Application number: 2020/92284	
What is the application for?:	Erection of single storey out building to provide home office/studio (within a C
Address of the site or building:	33, Wilshaw Road, Meltham, Holmfirth, HD9 4DZ
Postcode:	OL3 5TN

Type of comment: An objection
<p>Dear Sirs,</p> <p>The proposed development lies within green belt land and a conservation area and as such only development which enhances and preserves the local area should be allowed. The proposed works fail to preserve or enhance the conservation area in which they sit and as such the planning application must be refused. This application is on the site where previous planning approval has been disregarded and enforcement notices ignored. As such, any further planning requests must be considered with the utmost caution.</p> <p>The submitted application states the building cannot be seen from a public road or public footpath however this is incorrect. The planned building will be very clearly visible from Wilshaw Road down the East side of the existing dwelling and also from the public footpath which runs down Gill Birks Lane across the North side of the existing dwelling. As such, this development would be in

PROPOSED PLAN OF STUDIO/OFFICE 1:50 @ A2

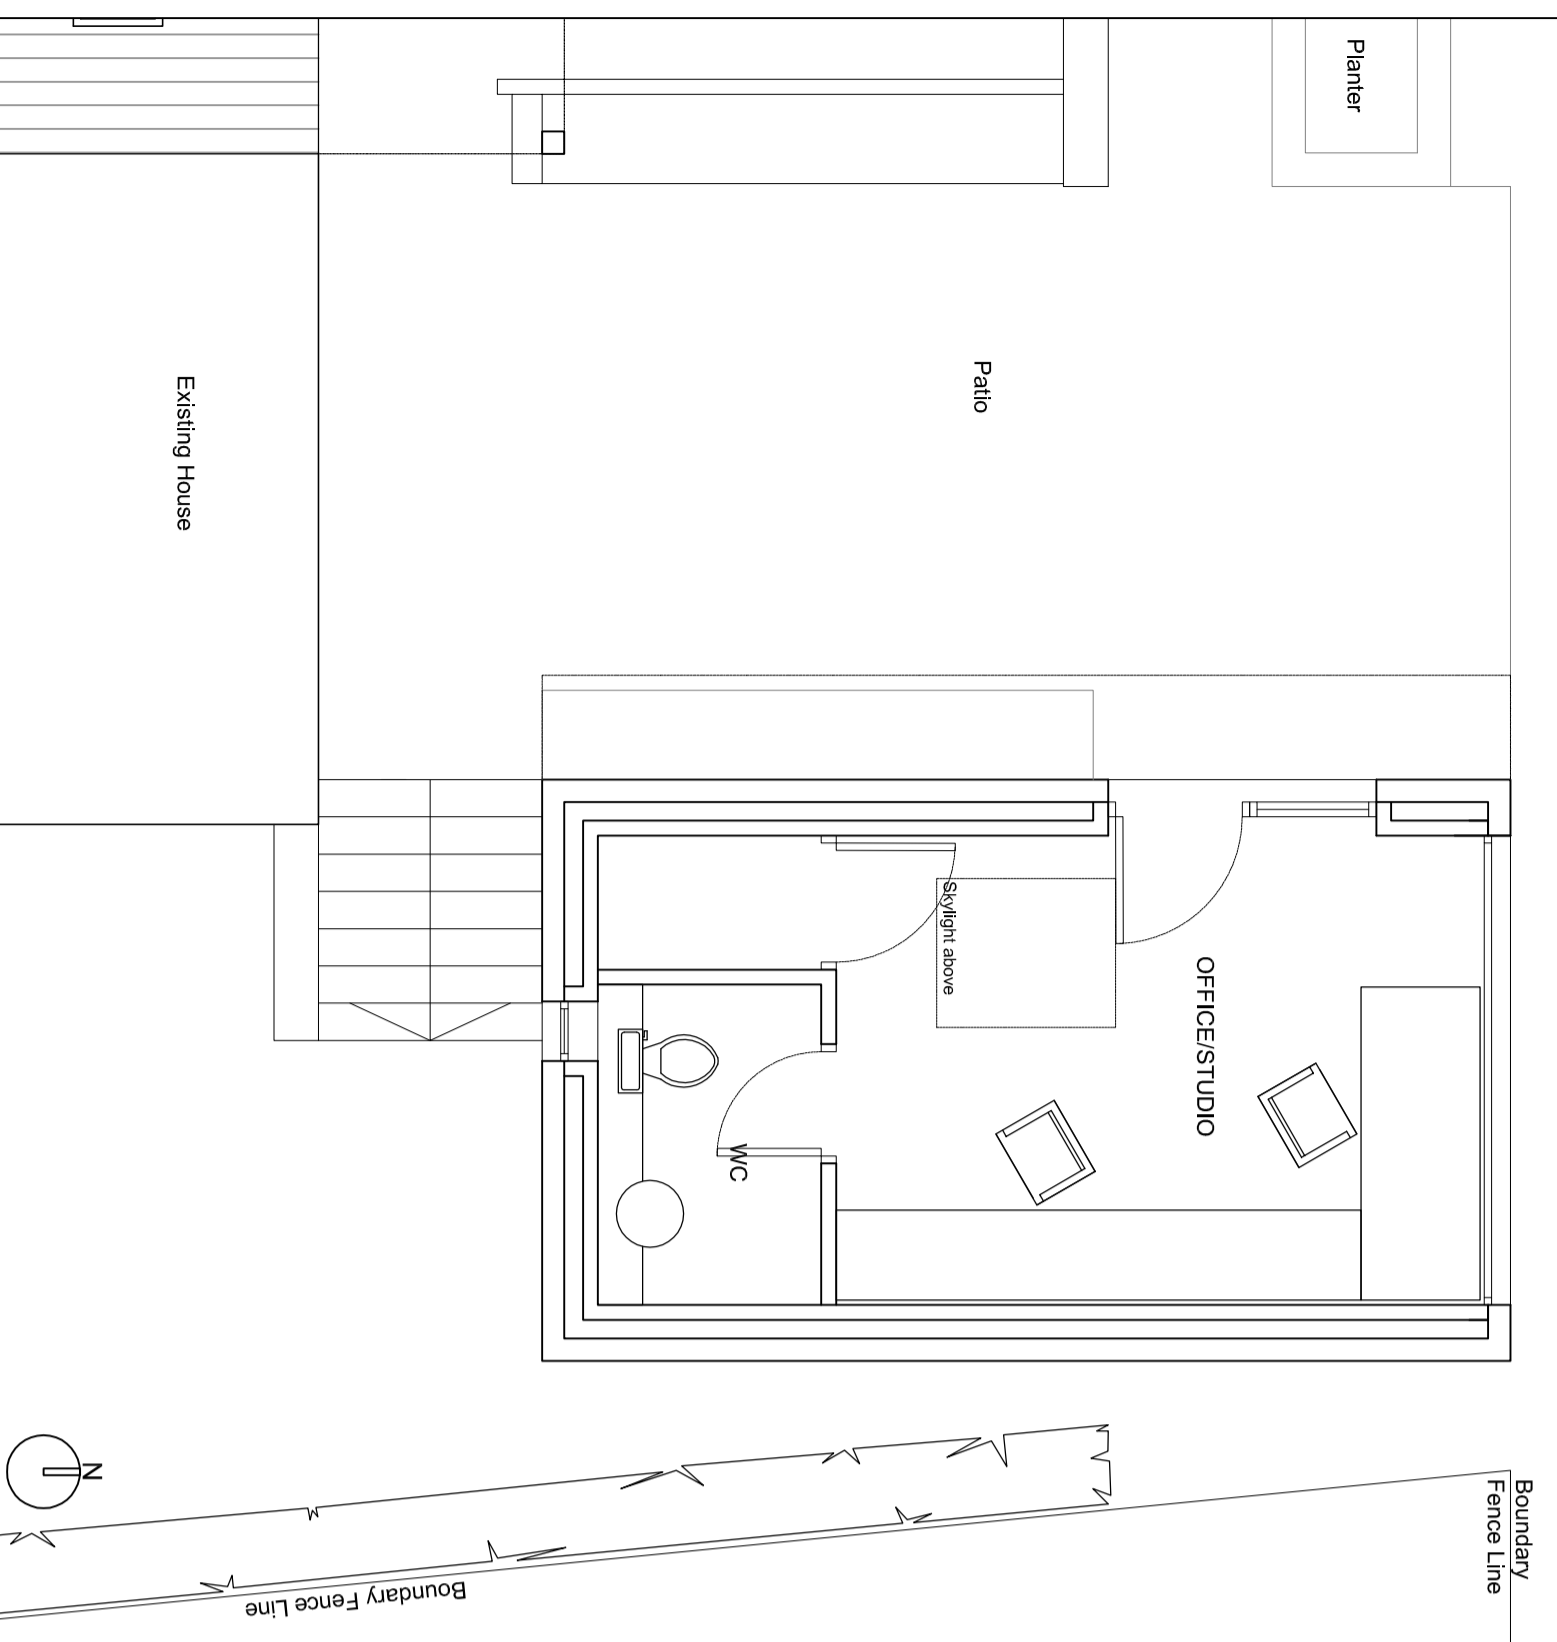
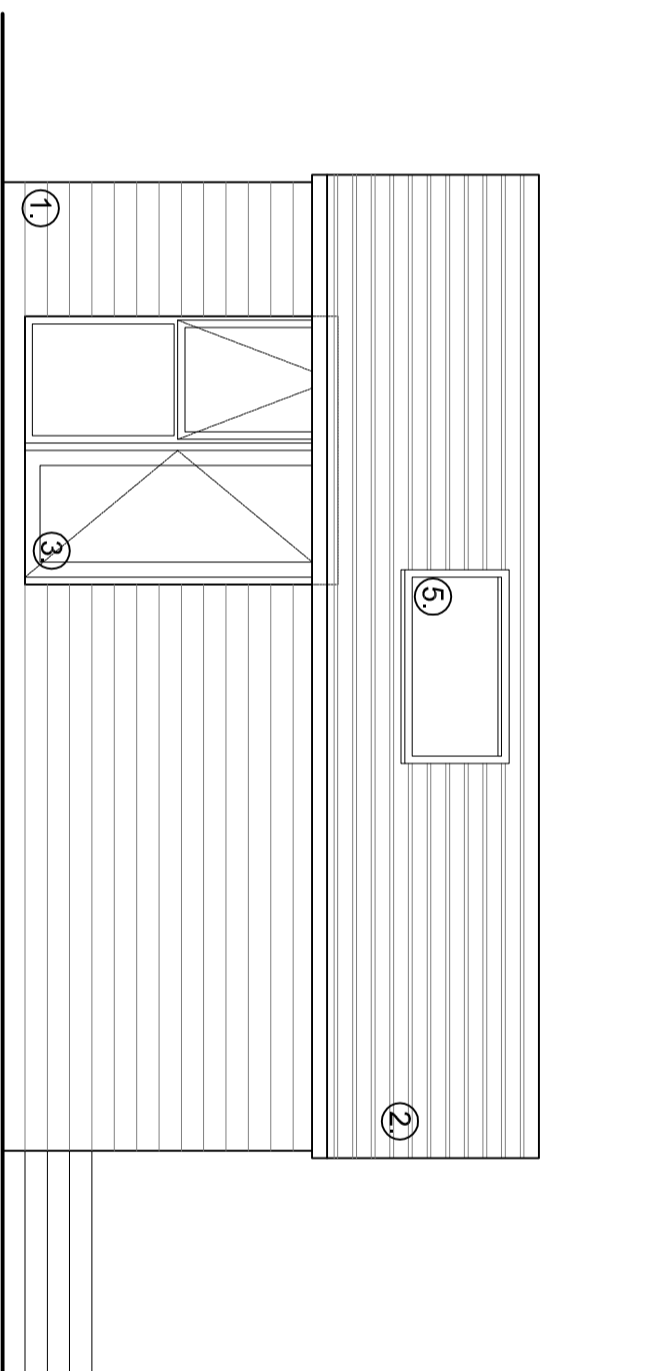
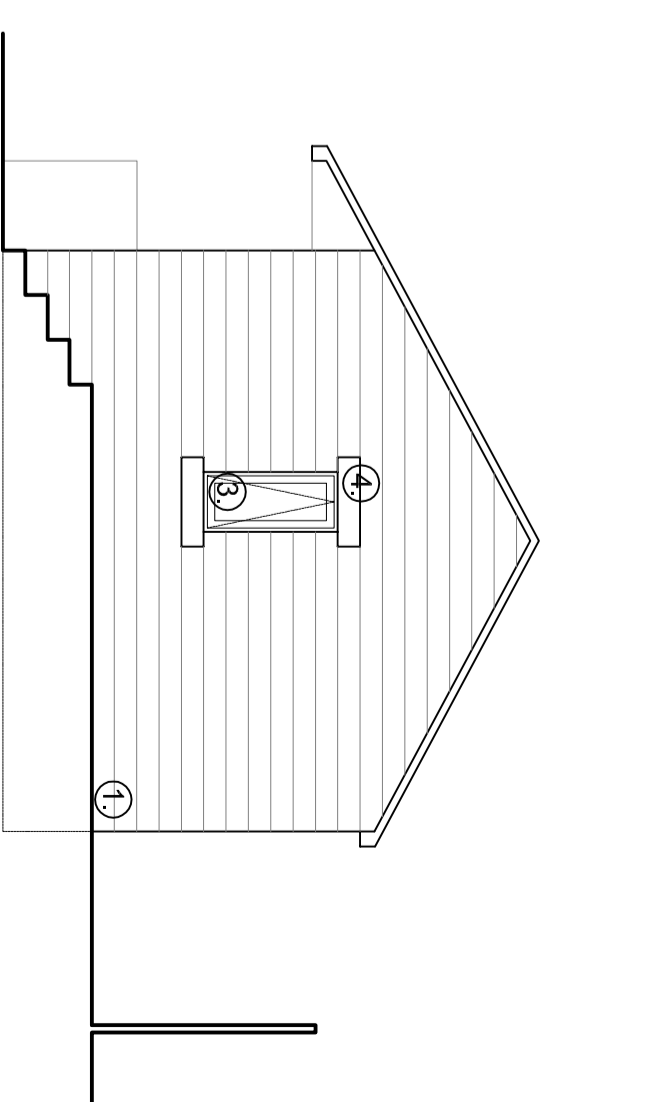
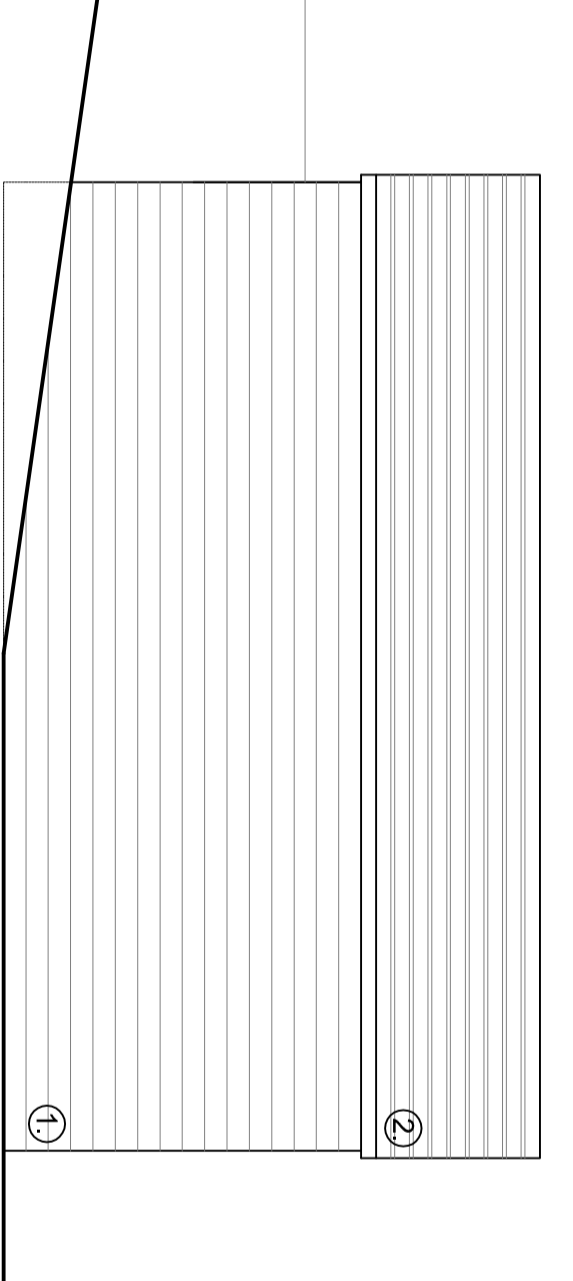
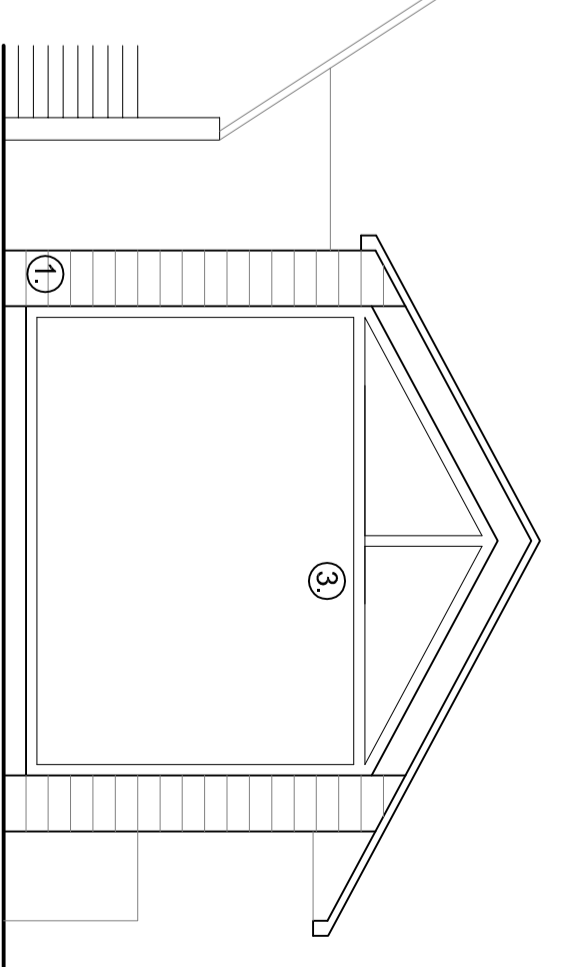
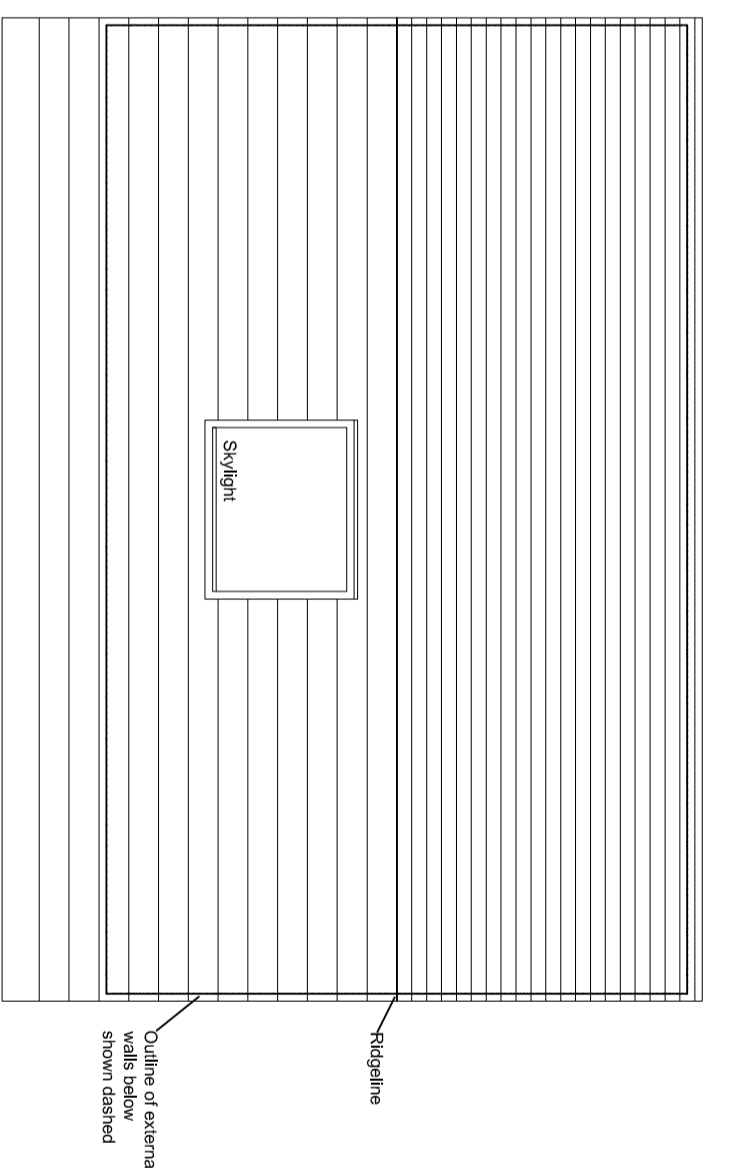
The Decision Notice 2017/62/9124/W states that the external walls and roofing materials of the detached garage should match those used in the construction of the existing building. The application states reconstituted stone would be used in the construction which would therefore not match the existing building as it is built of coarsed natural stone.
